Demolition of existing dwelling & erection of 1 No. dwelling, associated landscaping & parking (resubmission following K/11/16/PL).
Spring Tide Gorse Avenue East Preston

Thank you for your internet comments made on 19th December 2018 which has been recorded as **'an objection'** with the comments as follows:

Kingston Parish Council objects to this application for the following reasons:

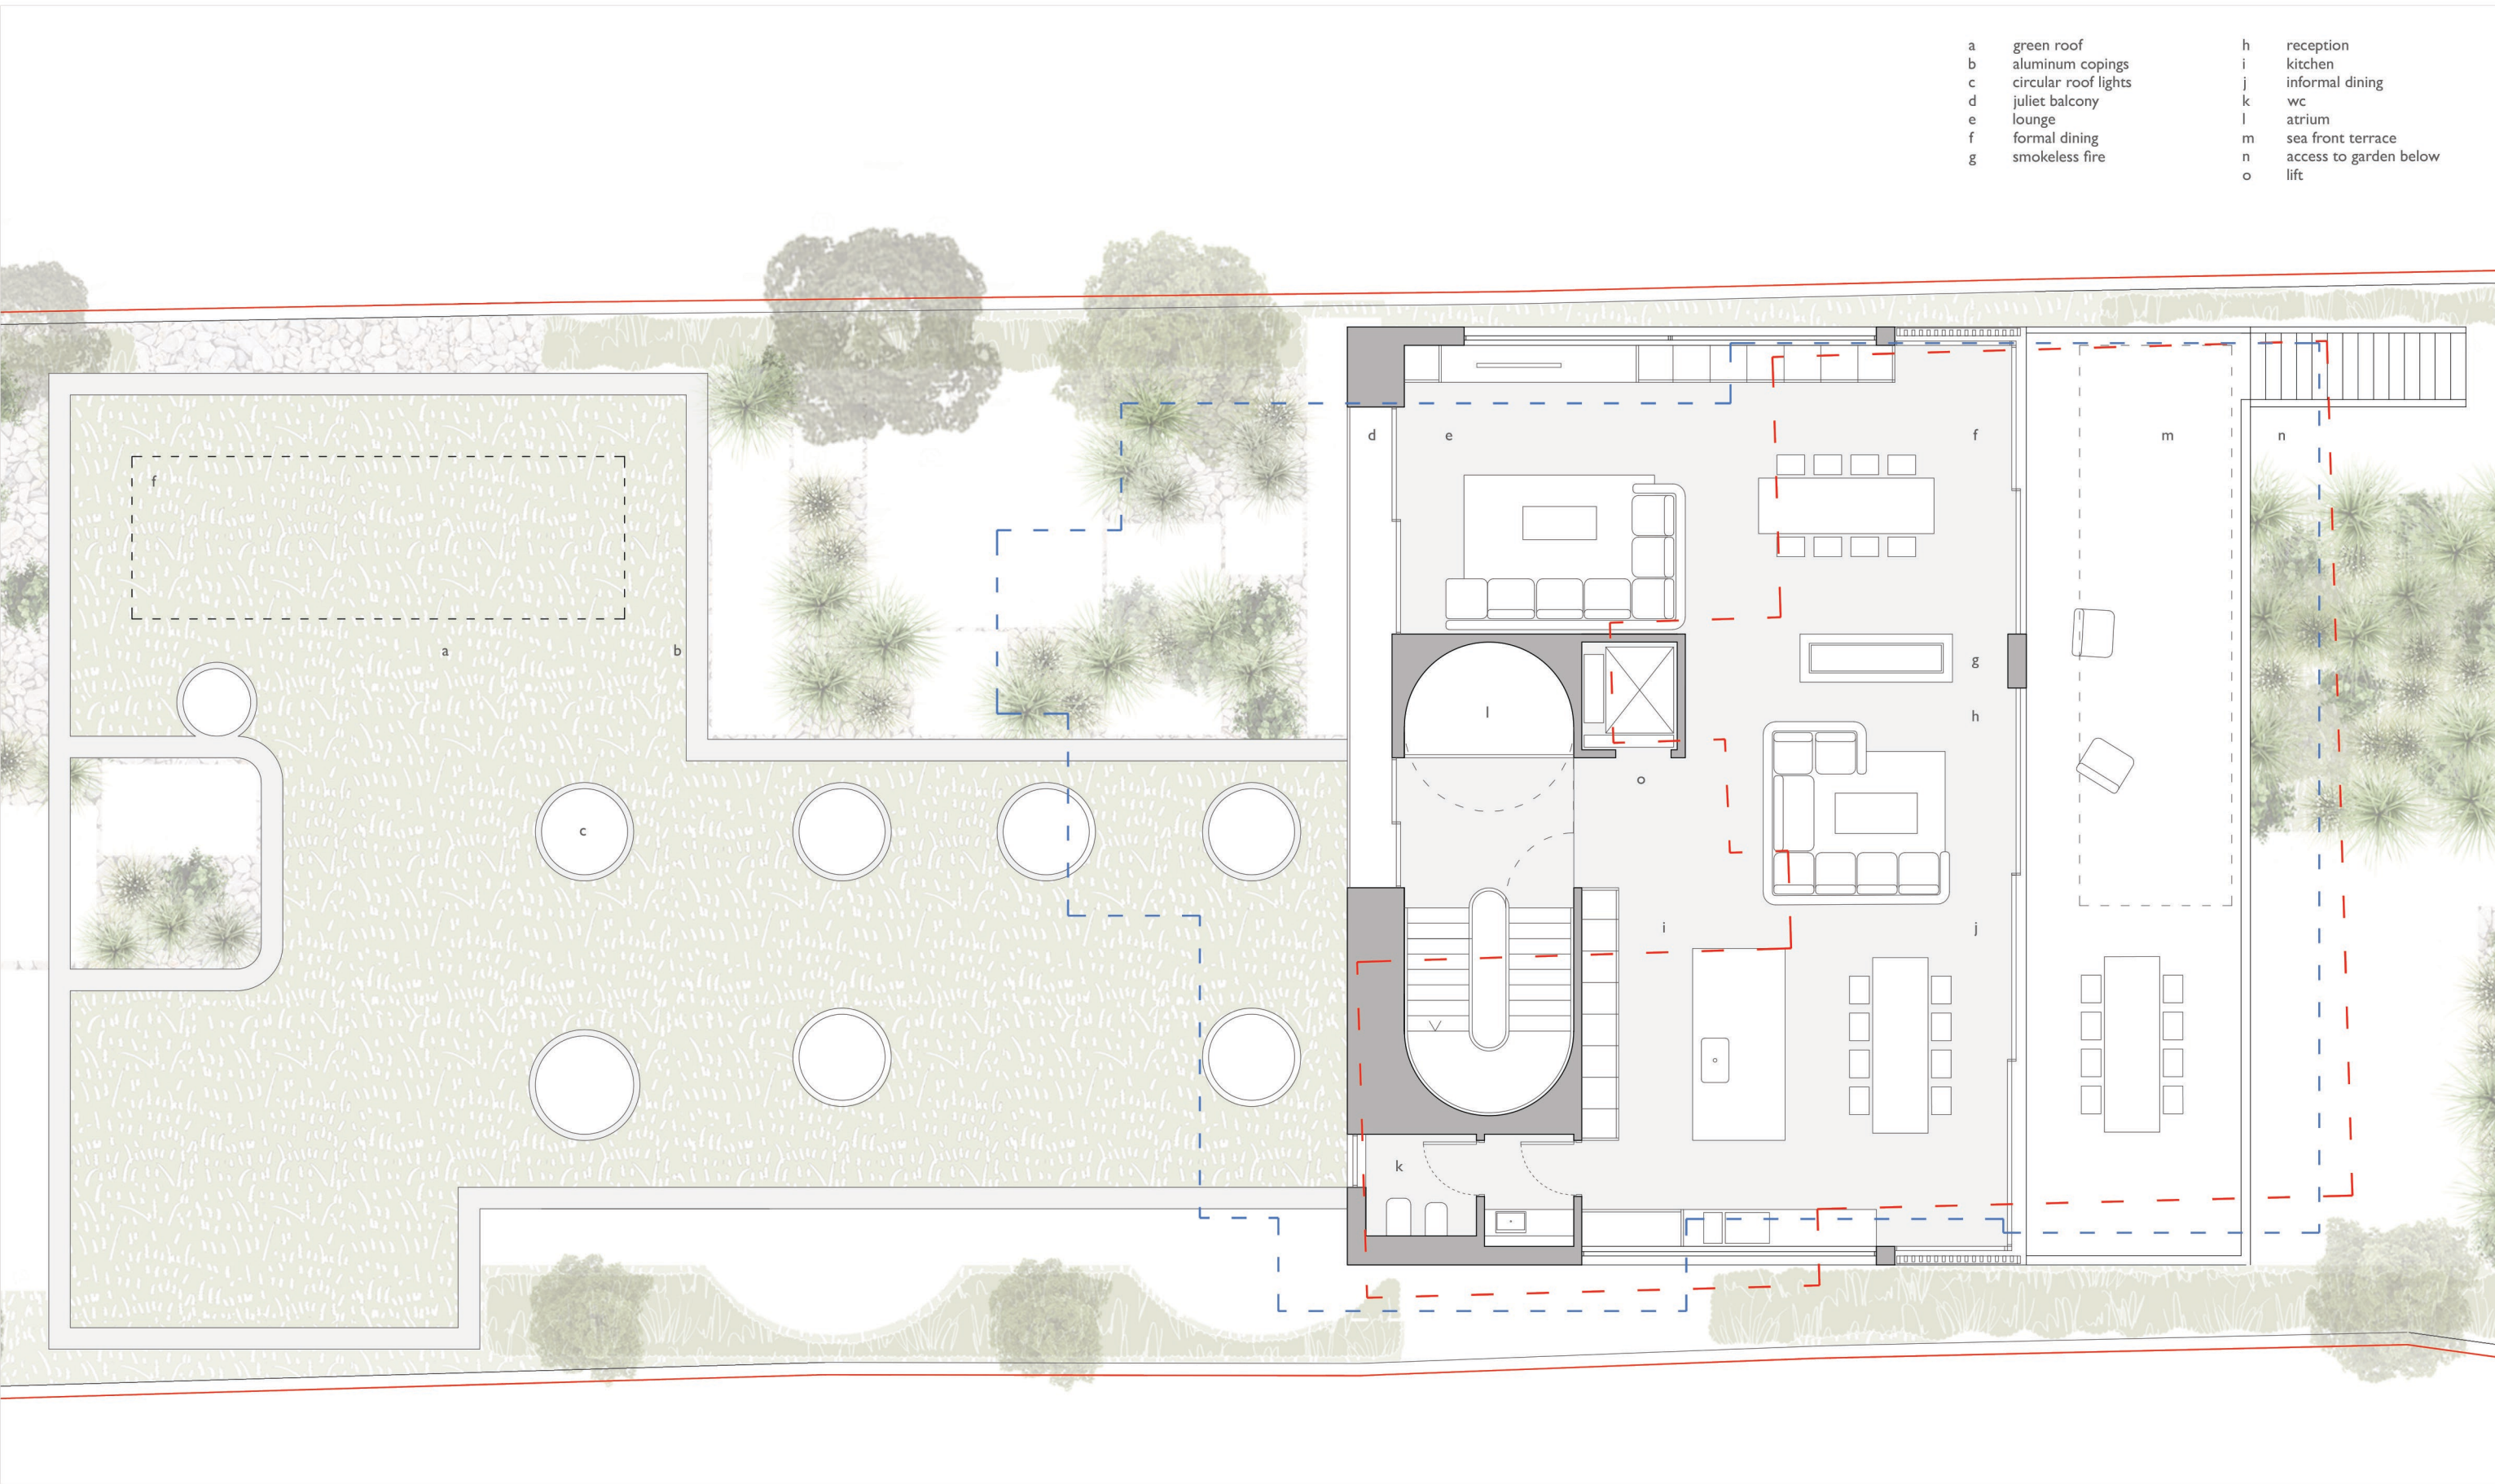
- 5. Council is concerned that it is intrusive to the privacy of neighbouring properties - balconies and the external staircase should have privacy screening to the side and overlooking windows should be fitted with opaque glass.*

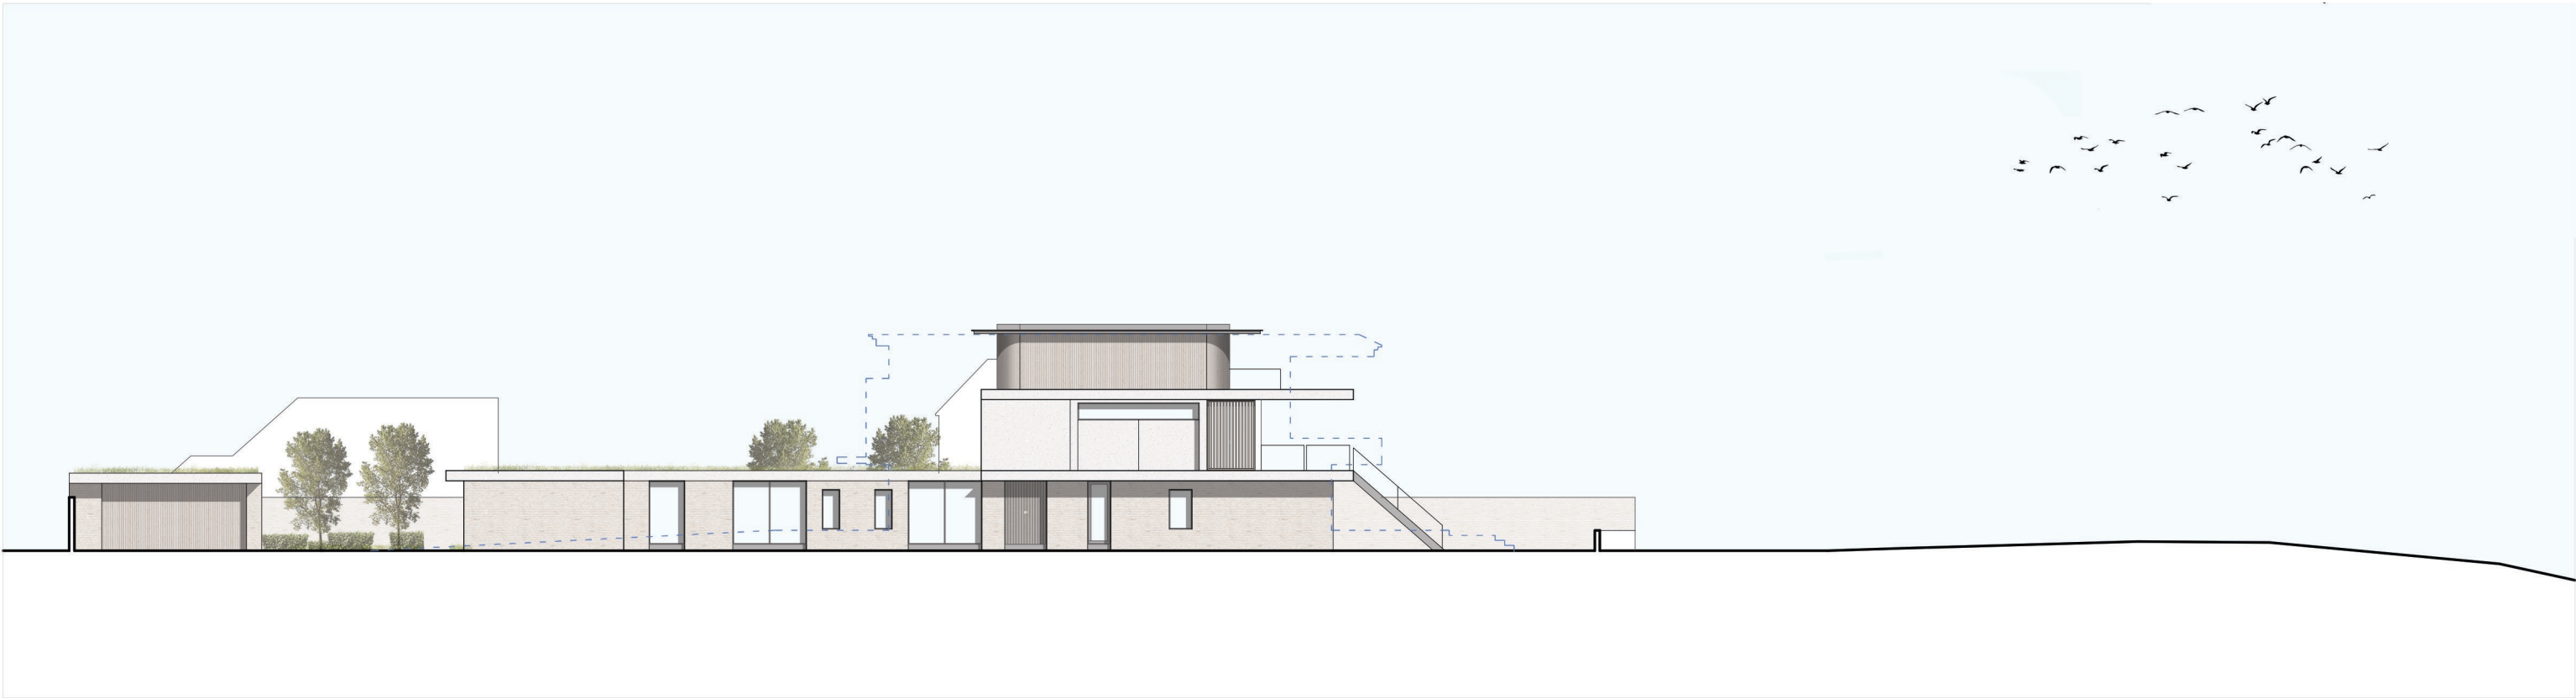
- 4. Council is concerned that the overall height of this new application for a three-storey dwelling is even higher than that proposed for the two-storey dwelling in approved application K/11/16/PL. This increase in height is shown in the drawing Proposed Street Scene plan dwg. 247-D-17 and together with the new flat roof design rather than a sloping roof the impact of scale on neighbouring properties is greater, particularly on the property to the east, and this also adversely affects the continuity of the street scene.*
